Description: Removal part dwelling/club and addition of ground floor club/dwelling improvements with first floor s/c flat over

Location: Lake Ross
Dozens Bank
West Pinchbeck

Amendment: Reduced scheme to dwelling house only
(Dwg no. 2/1)

**TOWN AND COUNTRY PLANNING ACT 1990
NOTICE OF ACCEPTANCE OF AMENDMENT**

DRA. NO. 2/1 A

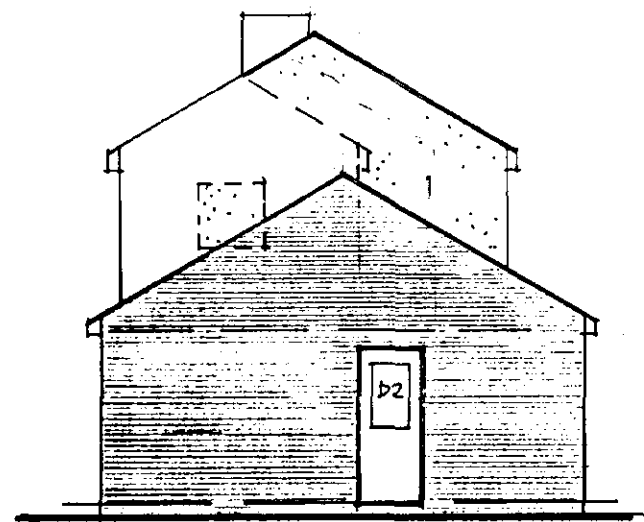
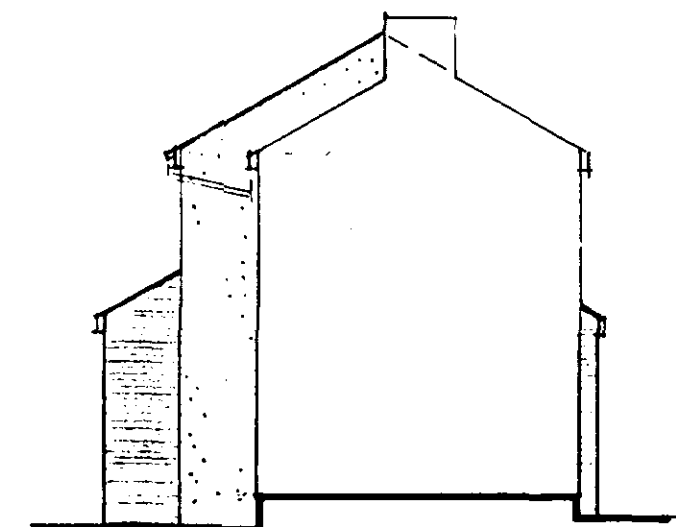
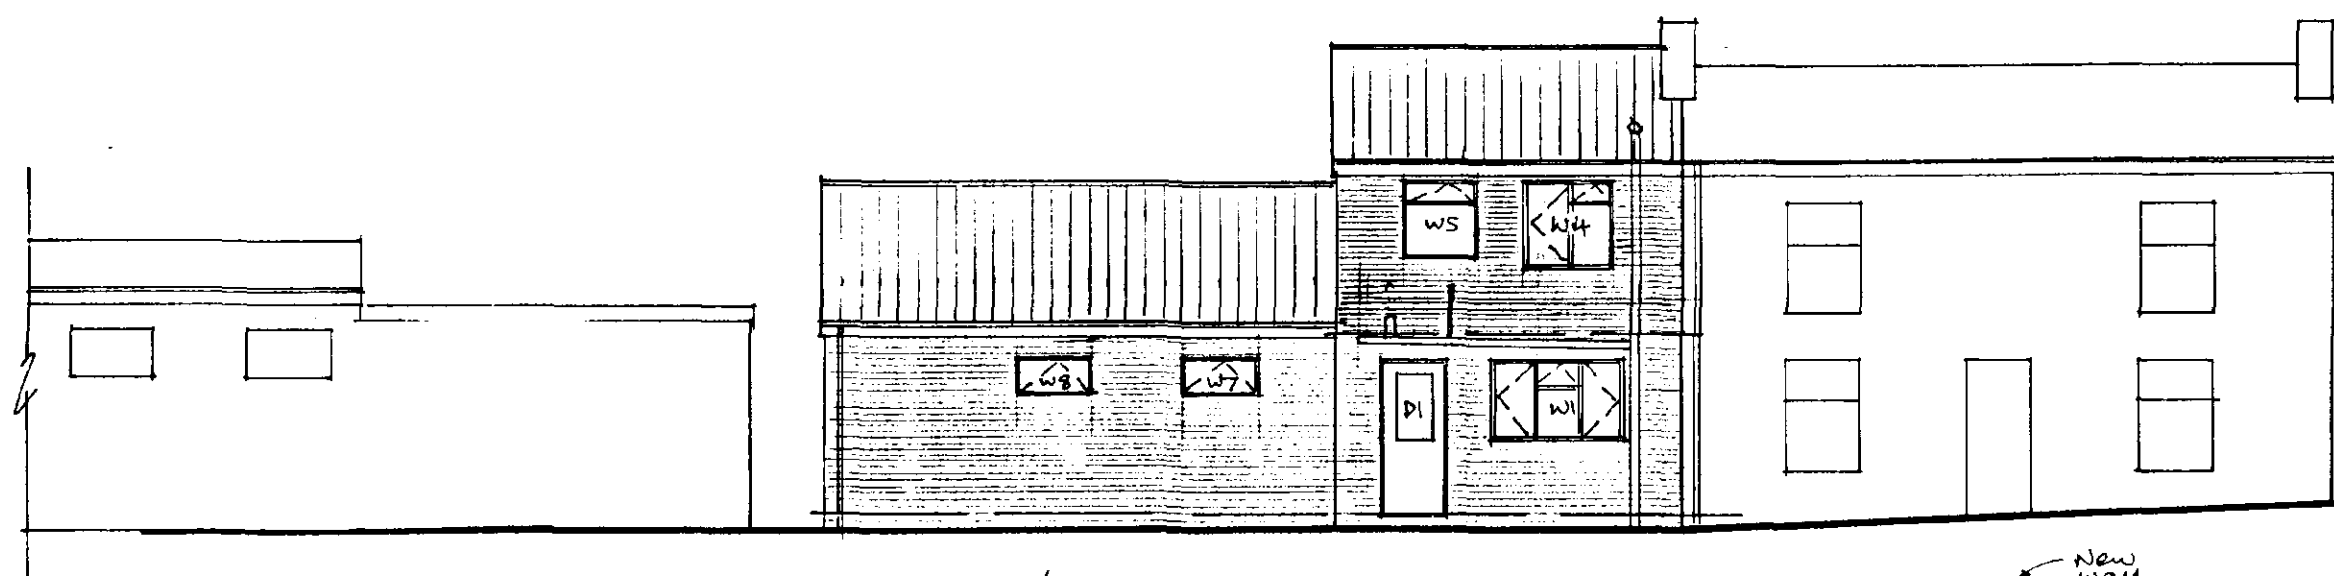
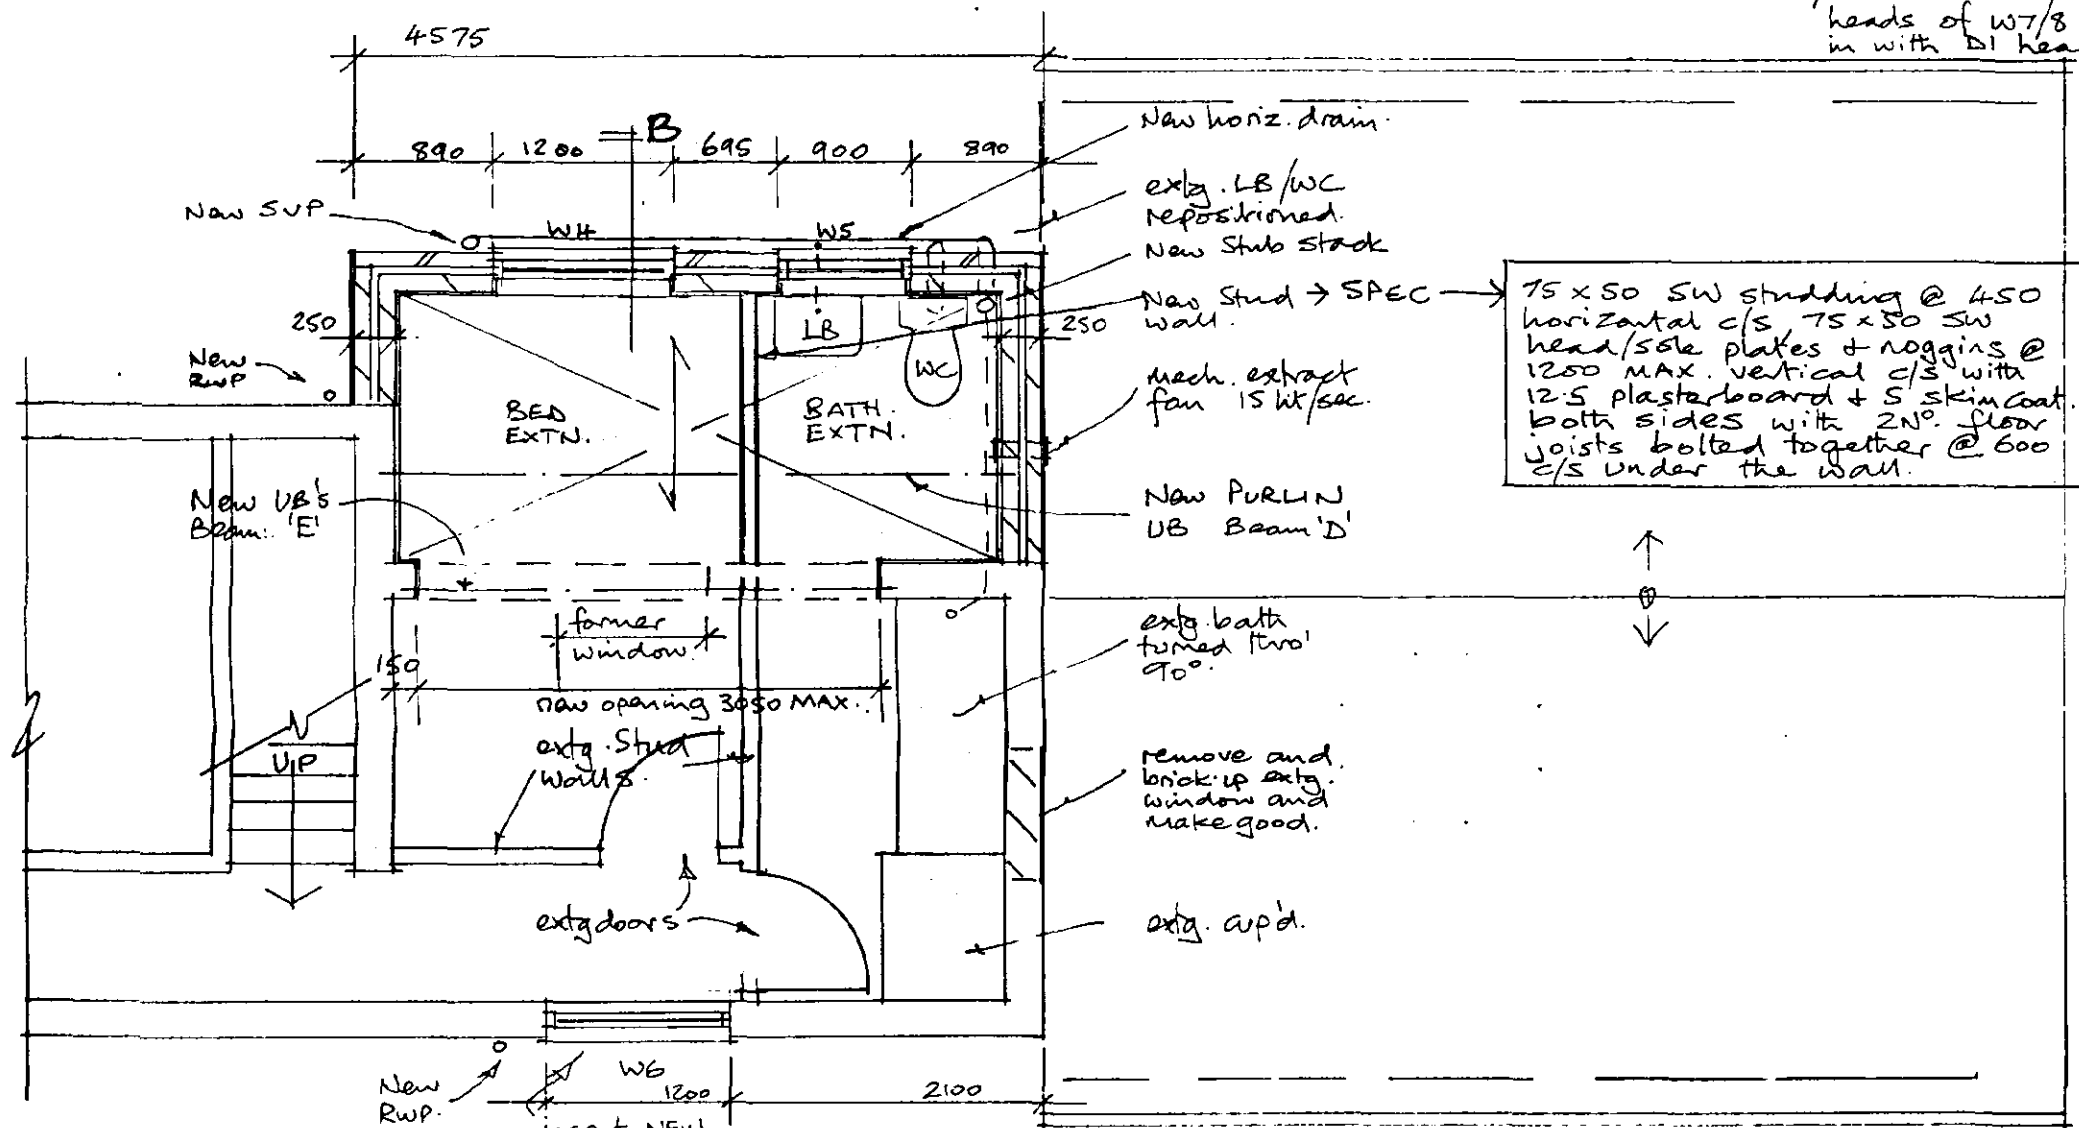
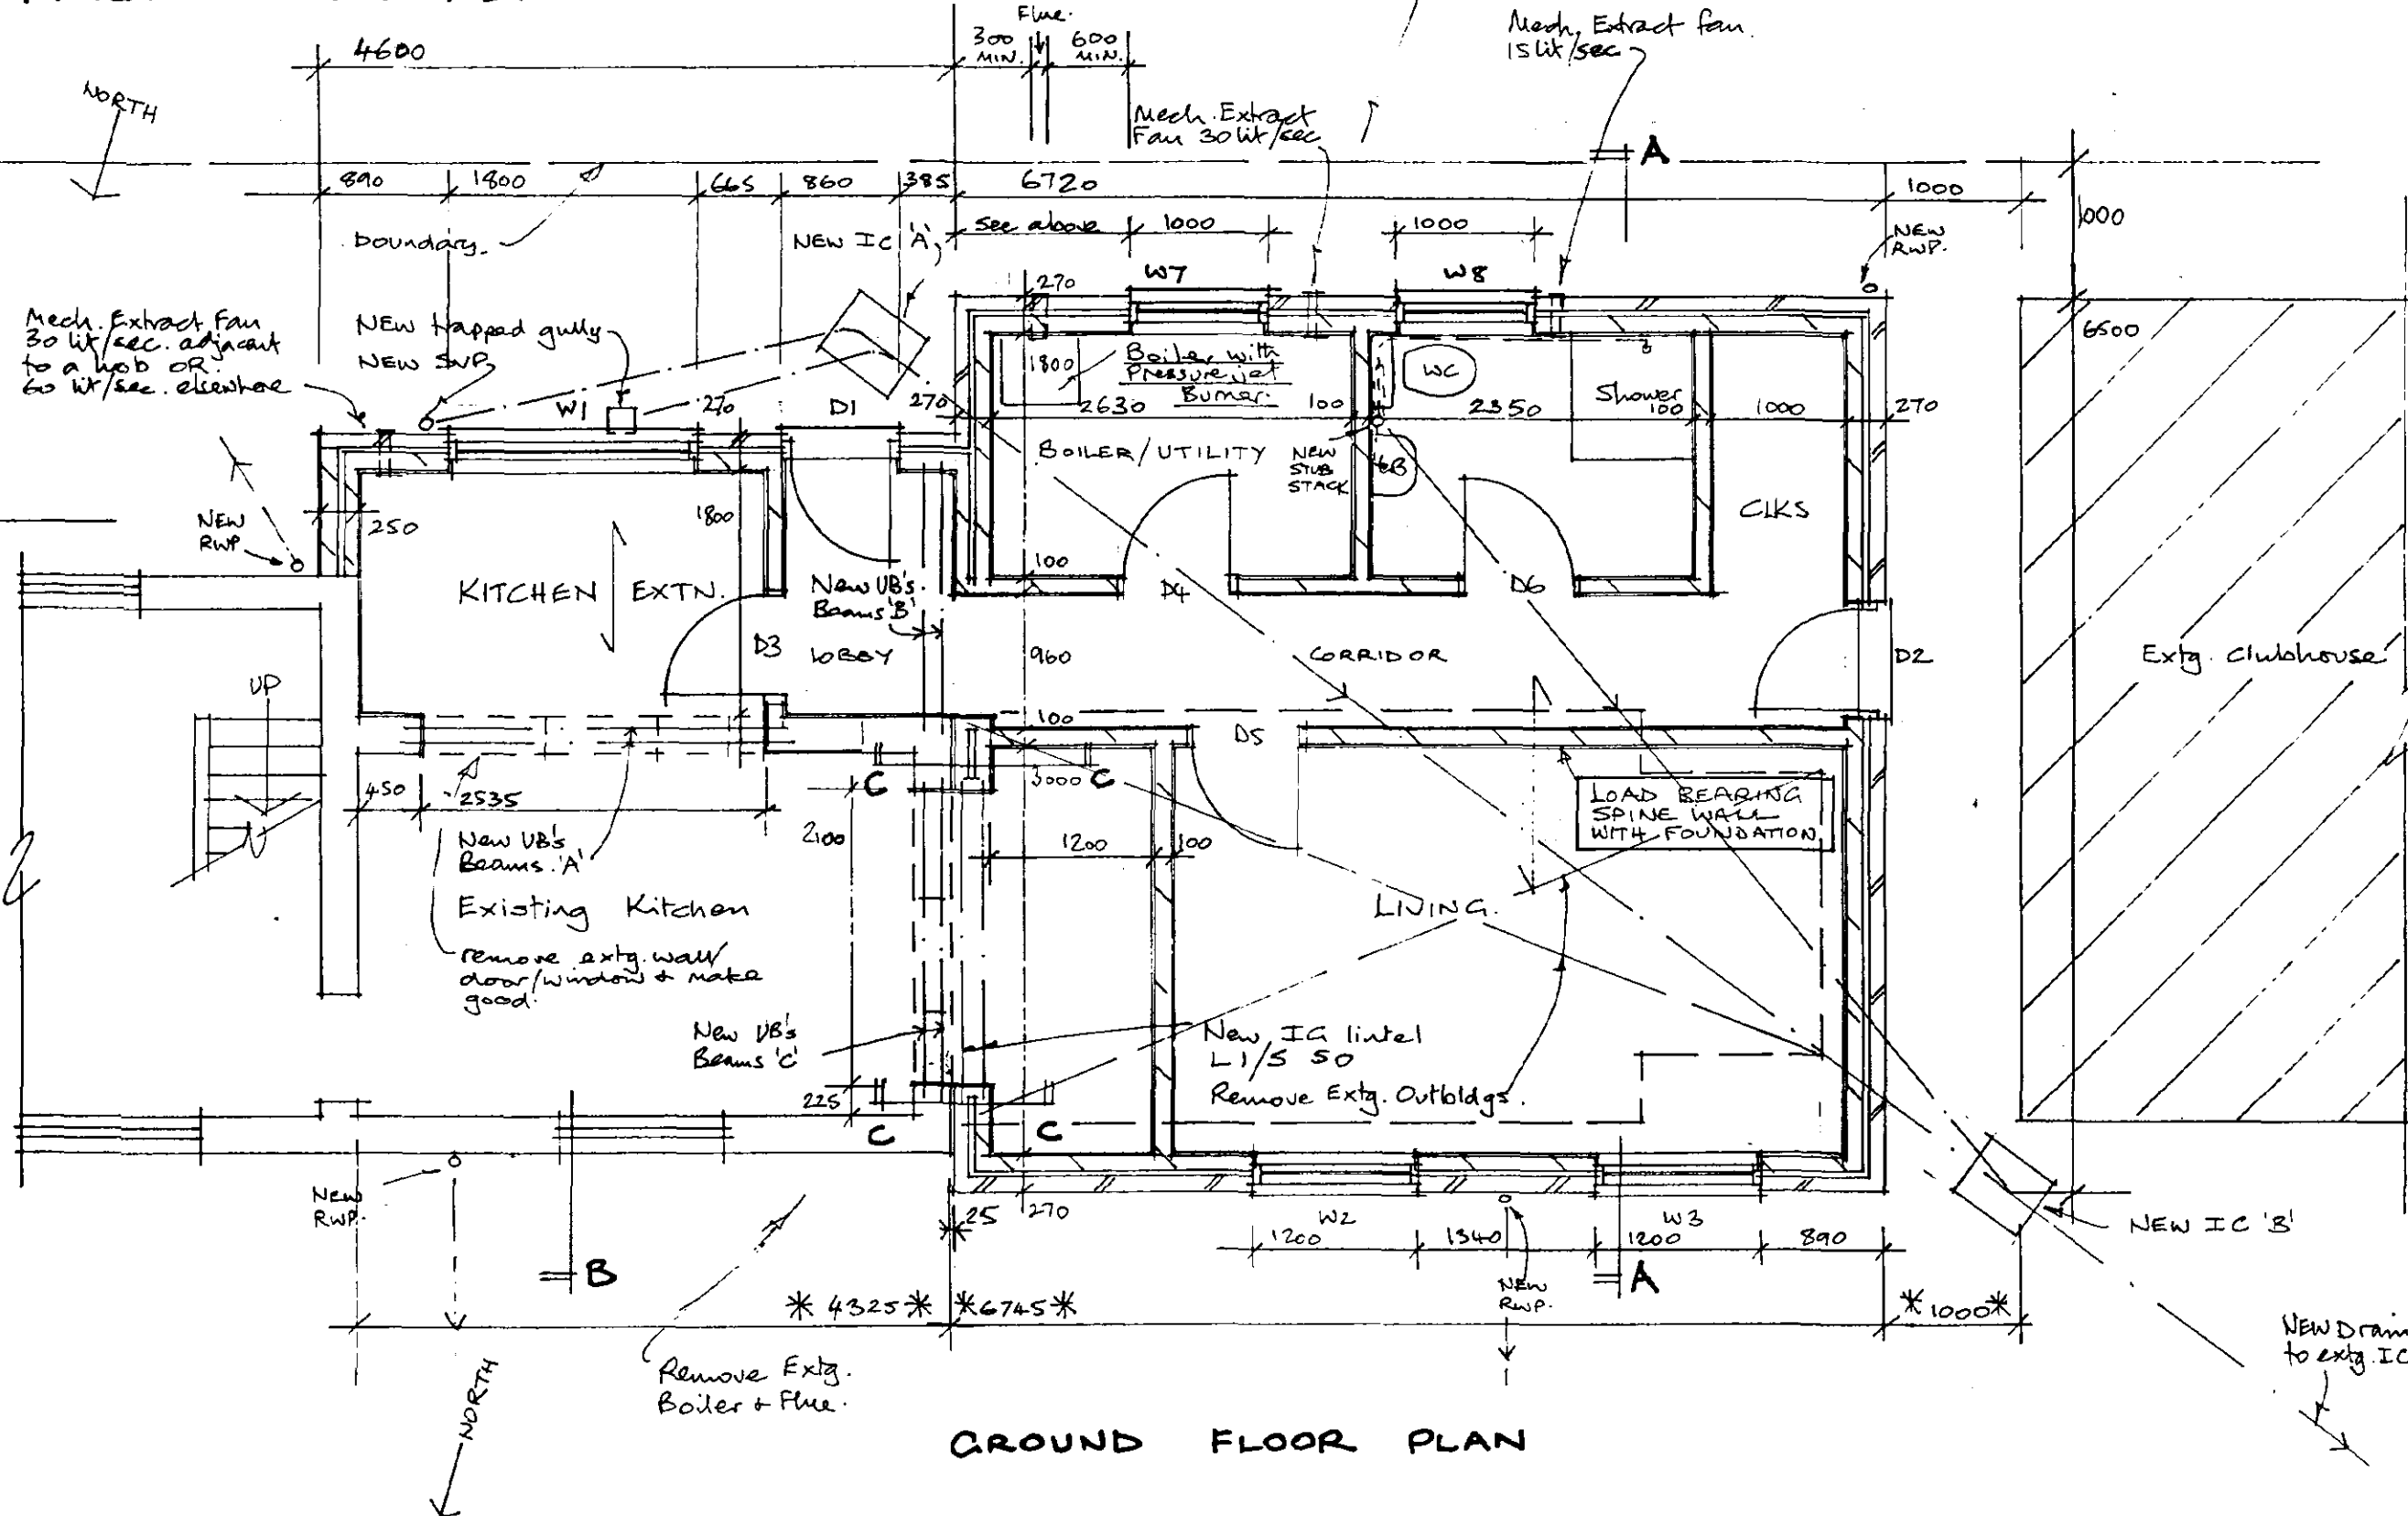
Amendment: Two extra windows added (W7 and W8)
Dwg. no. 2/1A

Since I wrote originally my Client has asked for 2 extra
windows, which I have numbered W7 & W8. A copy of drg. no.
2/1A is enclosed for your further information.

The amended details submitted in respect of the above proposal have now been considered and there are no objections to the amendment being implemented to the extent described above.
